KITTITAS COUNTY COMMUNITY DEVELOPMENT SERVICES

RE: CU-23-00002 The Outpost – Request for Additional Information

After consulting with the Washington State Department of Ecology, it has been determined the submitted site plan (updated site plan received 10-16-2023) depicts development occurring within shoreline jurisdiction. To proceed with processing CU-23-00002 The Outpost, CDS needs one of the following items to be submitted.

**CONCEPTUAL SITE PLAN
MULTIPLE PARCELS**

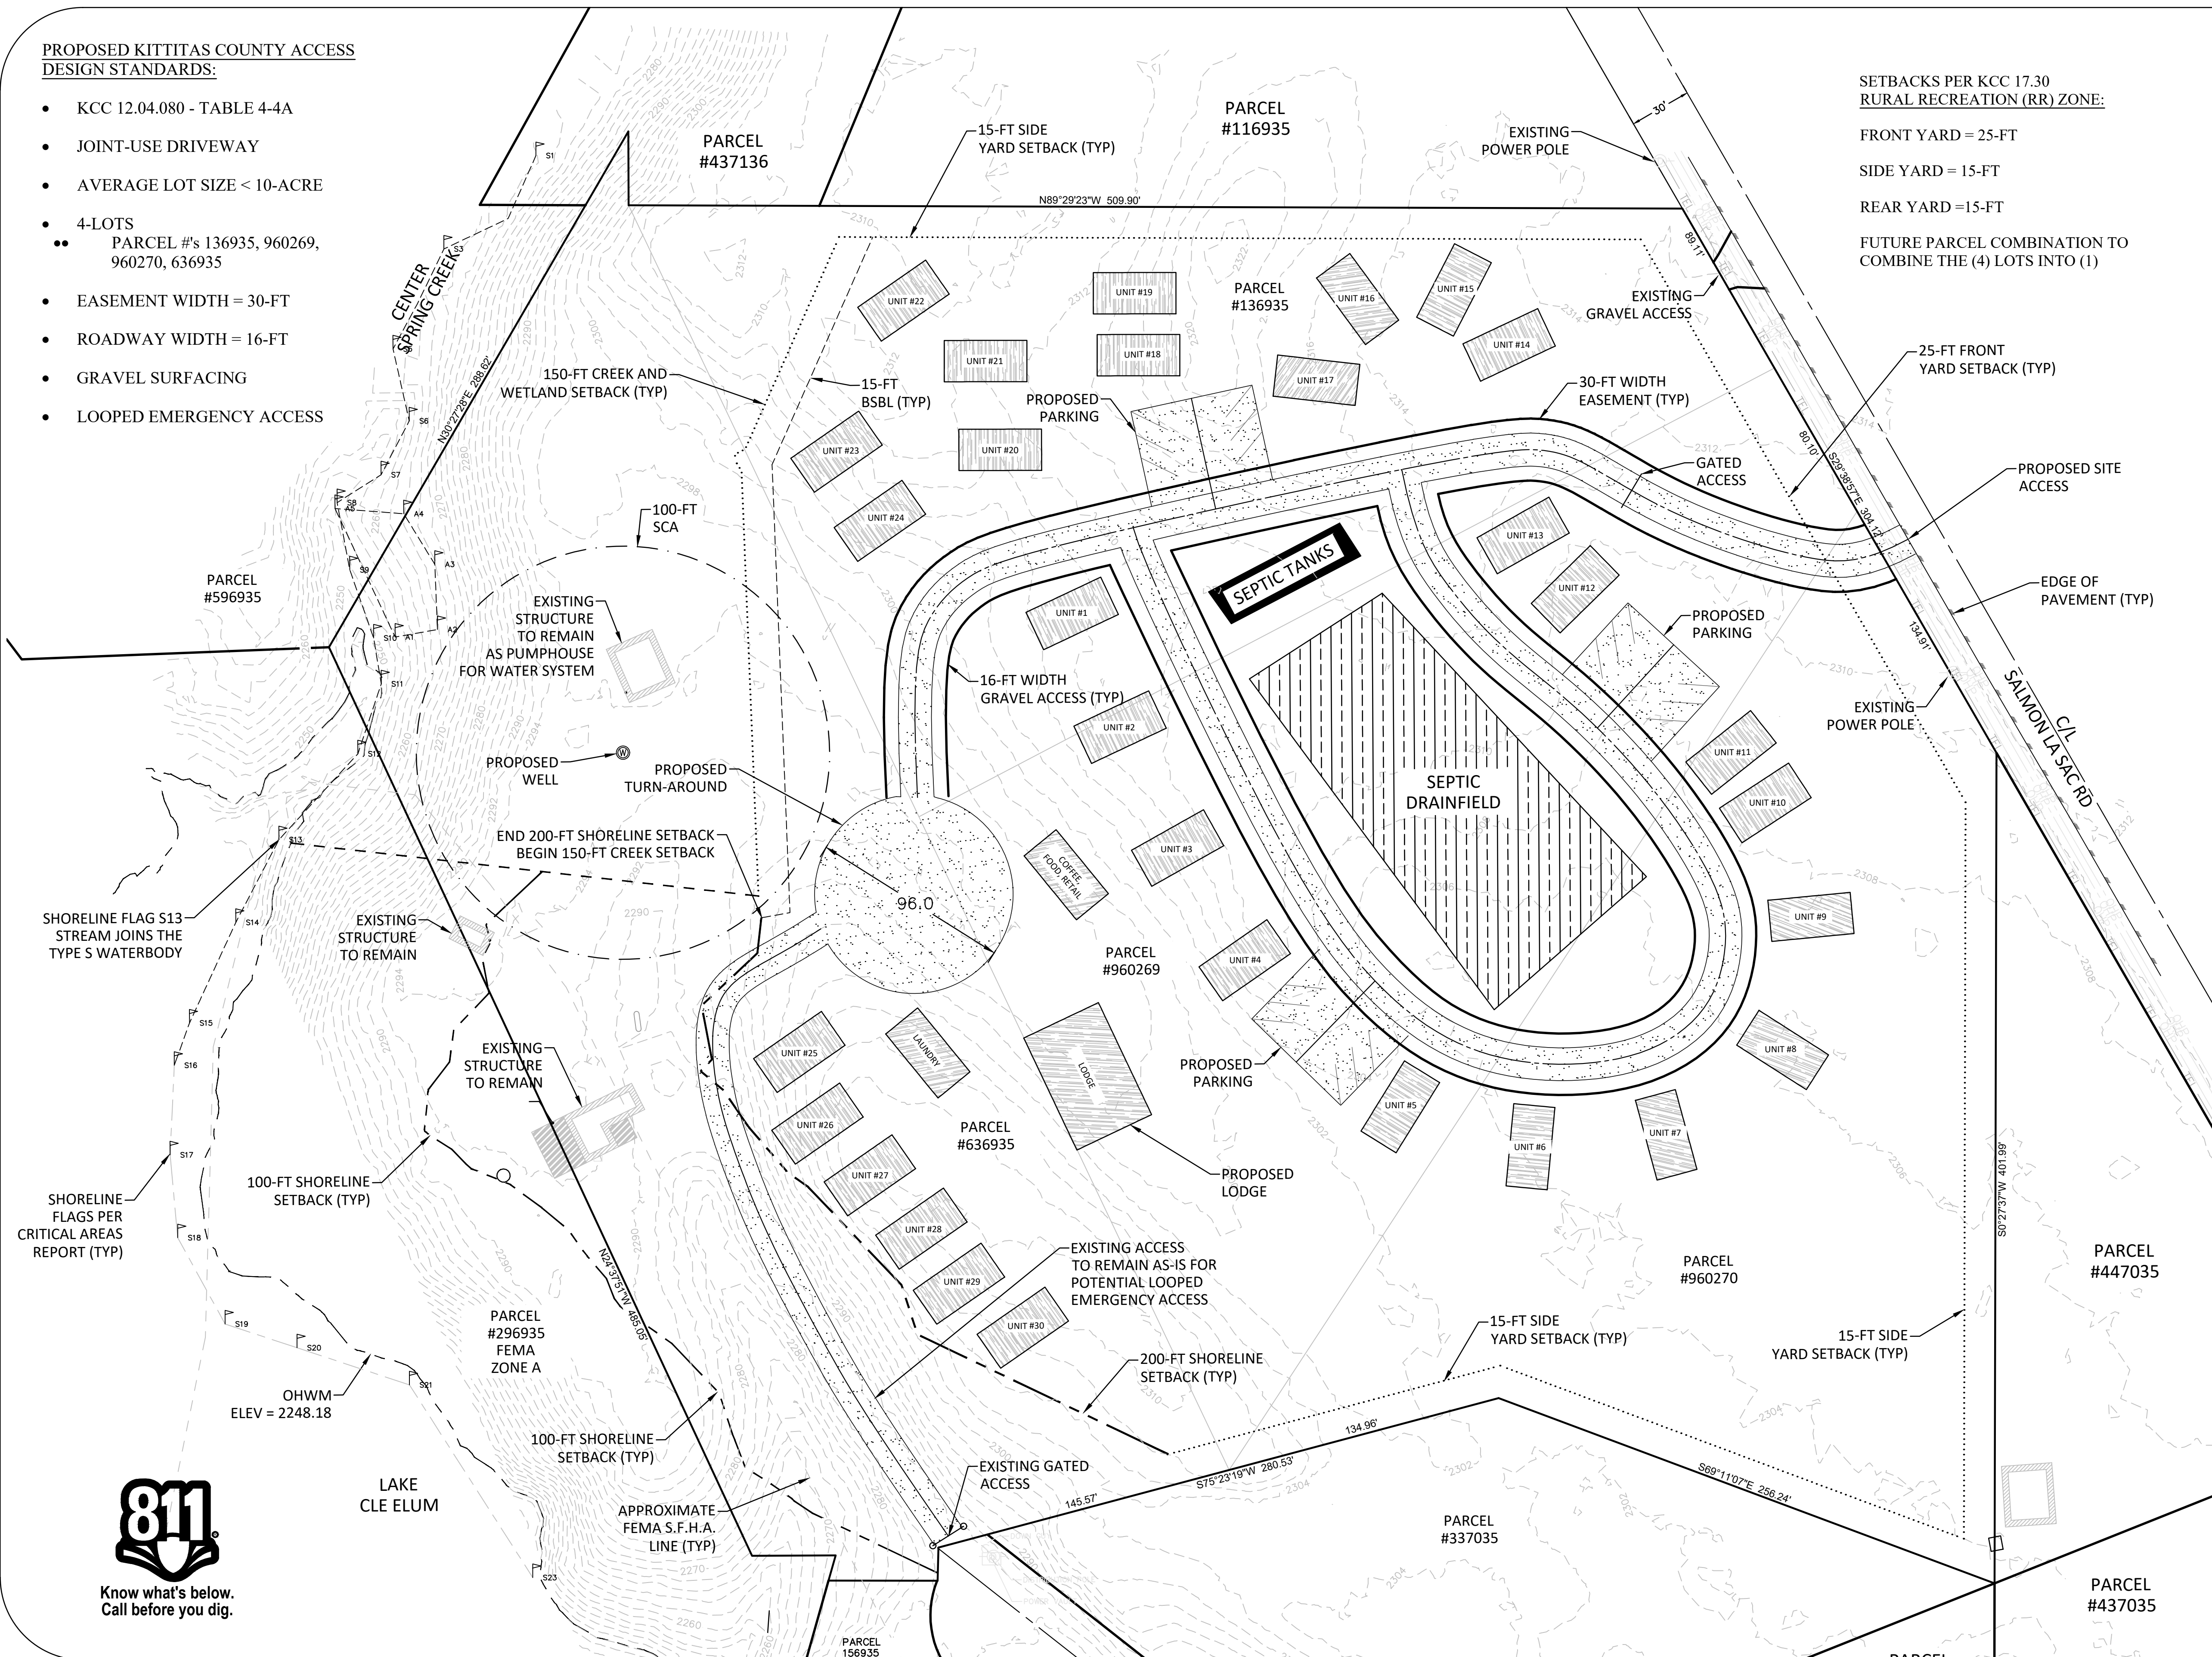
- a) The proposed well, as depicted in the site plan submitted on 10/16/2023, is located within shoreline jurisdiction and within the 150ft buffer of the Category III wetland. Please relocate the proposed well at least 200ft from the OHWM of the Lake Cle Elum shoreline and at least 150 feet from the boundaries of the Category III wetland.

- a) Development within shoreline jurisdiction is subject to the provisions of Title 17B of Kittitas County Code. As such, the project, as currently proposed, will require a Shoreline Substantial Development Permit to be approved prior to further processing of your Conditional Use application.
- b) The well must be located at least 150ft from the boundaries of the Category III wetland. The current site plan depicts the well approximately 105ft from the nearest wetland boundary.
